Director Infrastructure Projects
Department of Planning and Environment
Major Projects Assessment
GPO Box 39
SYDNEY NSW 2001

PROPOSED NORTHCONNEX M1 / M2 TUNNEL PROJECT - Application Number - SSI 13_6136

We object to many aspects of this project

MOTORWAY OPERATIONS COMPLEX - SOUTHERN VENTILATION FACILITY - SECTIONS
M1-M2-5000-DR-JD-0525

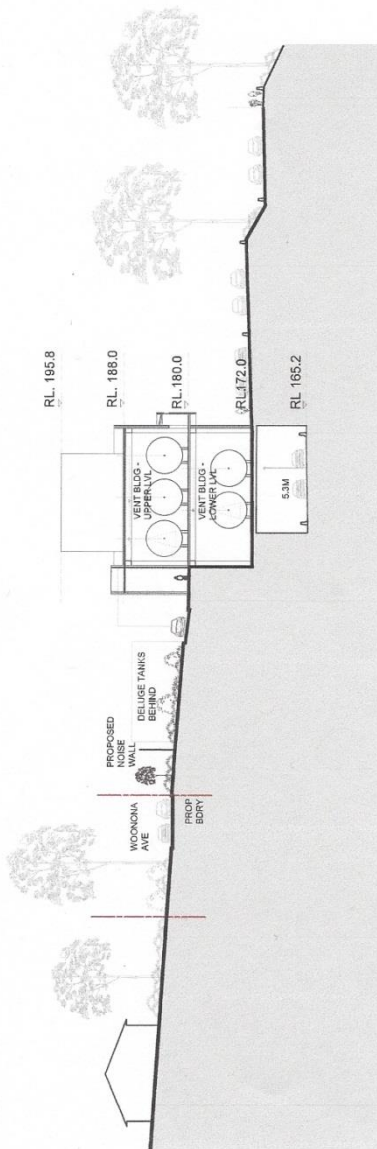
1. The Environmental Impact Statement (EIS) does not show any connection between the ventilation stack and the southbound tunnel which is 250 metres away. Will the polluted air be allowed to flow like an invisible sewer through West Pennant Hills, North Rocks, Carlingford and Beecroft?
ACTION: Provision of diagrams and detailed description of what ventilation is proposed for the southbound tunnel at the Southern Interchange. We would like the opportunity to lodge further submissions once that has been provided.
